Reference No: **2026/NM/90771/E**

Site Address: The Priory, Whitechapel Road, Cleckheaton, BD19 6HR

Description: Non material amendment to previous permission 2025/90655 for demolition of existing pub and erection of two storey building comprising 8 self-contained supported living flats with ancillary staff facilities, single storey summer house and other associated works

Officer Report – 2026/90771

Dwg No. H24-WC - 014 Rev. D
 Drawn/Checked: NF
 Scale (A3) : 1 : 200
 Date: 23 Jan 25
 Client: N/A

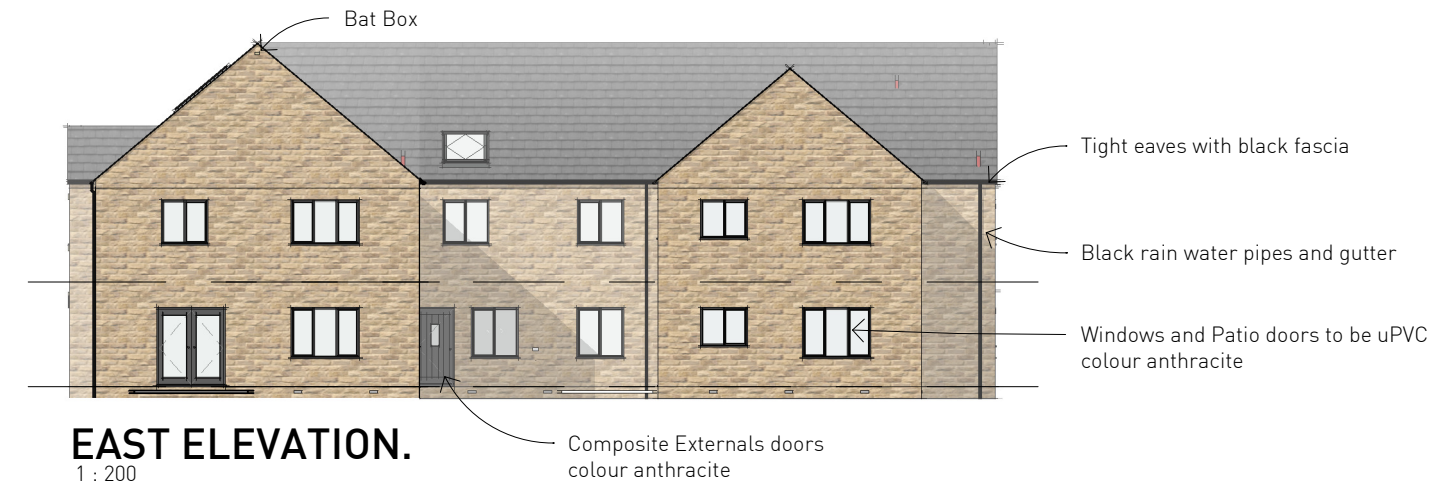
- To change the previously approved arched stone head with a straight stone head detail to main entrance on the south elevation.

The amendment relates solely to a minor change in elevational detailing, replacing the approved arched artificial stone head with a straight stone head above the entrance on the southern elevation. This is a limited design refinement which does not alter the approved scale, massing, footprint or overall composition of the building.

2025/90655. Accordingly, the development shall be carried out in accordance with the amended drawing no. H24-WC-014 Rev C, titled ELEVATIONS – Materials in so far as the stone head above the entrance on the south elevation, and all other approved plans and conditions attached to planning permission ref 2025/90655 shall continue to apply.
